City of Albuquerque

RE: Drainage Report and Grading and Drainage Plan for Sedona Subdivision Unit II, (B10-3A) Submitted for Preliminary and Final Plat Approval, Engineer's Stamp Dated 10/21/99.

CITY OF ALBUQUERQUE  
PUBLIC WORKS DEPARTMENT  
ENGINEERING DEVELOPMENT GROUP  
VENTANA RANCH, SEDONA SUBDIVISION, TRACT C-1  
DRAINAGE REPORT - EXHIBIT B  
GRADING PLAN - WEST PORTION OF SITE

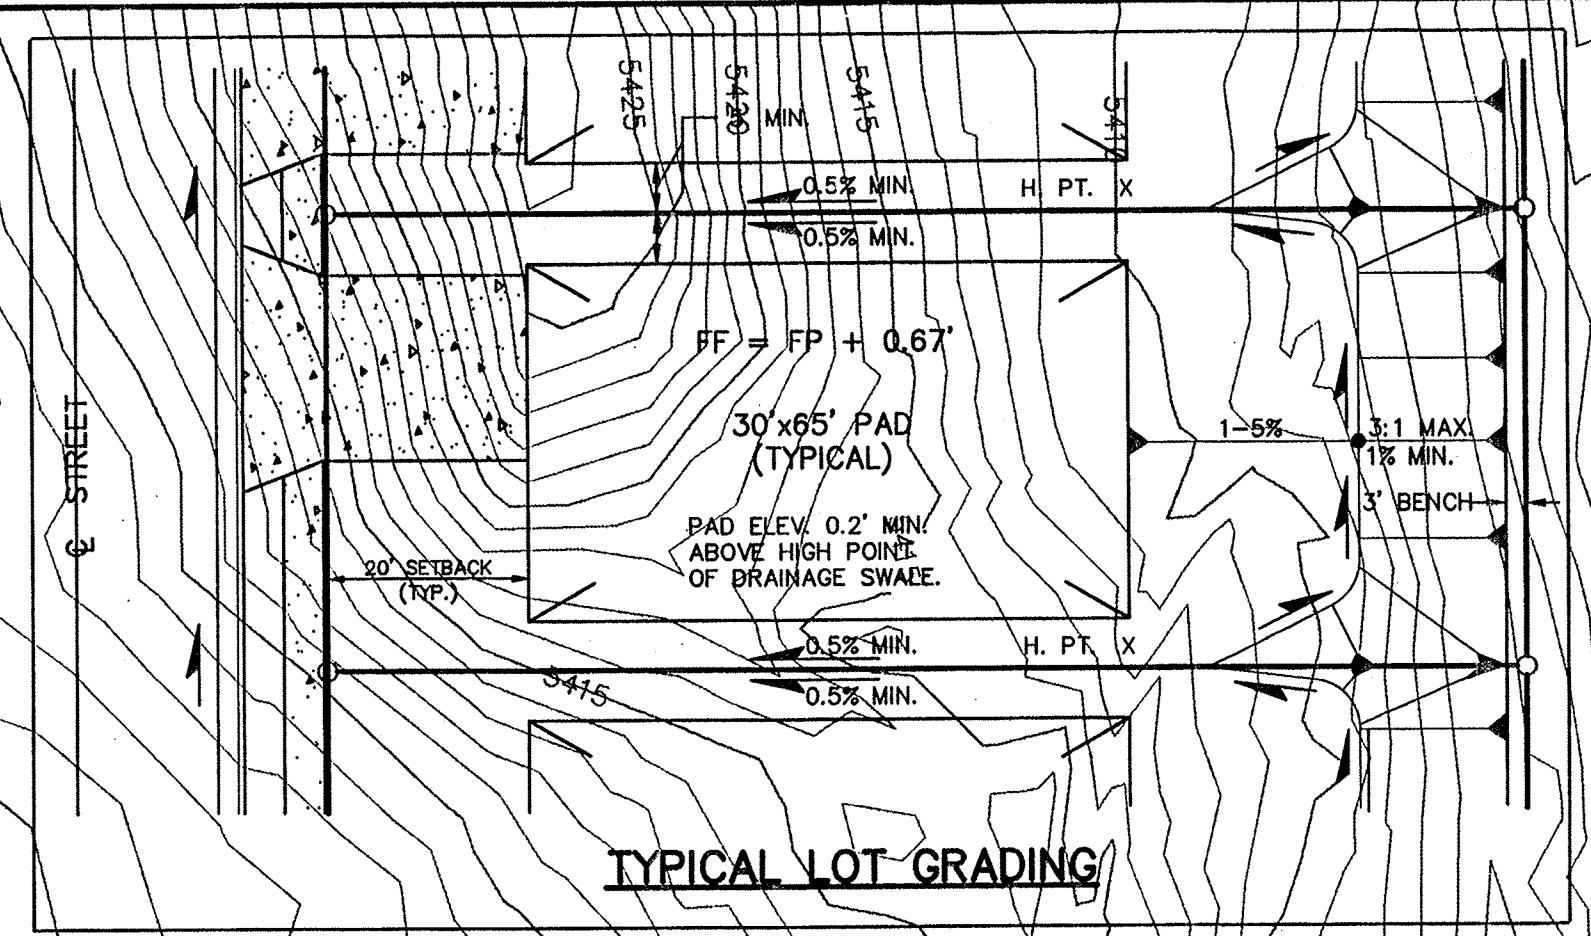
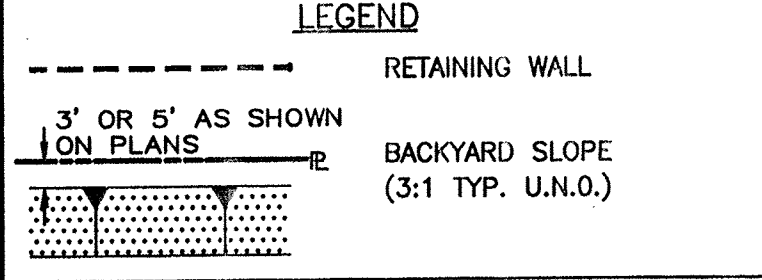
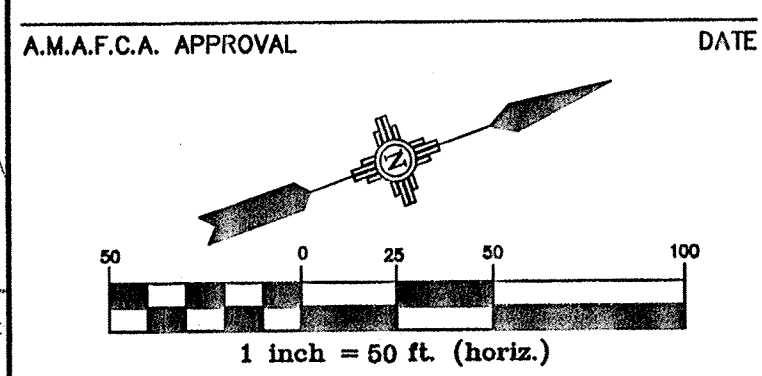
Per your letter of November 12, 1999, the drainage plan may be revised in the near future to change the width of the lots. When this occurs, a revised grading plan must be submitted to my office for review and approval. The revised grading plan must also be approved by the DRB. This may be done with the DRB approval for Final Plat. On the revised grading plan, please provide existing off-site spot elevations on the developed lots adjacent to the proposed development.
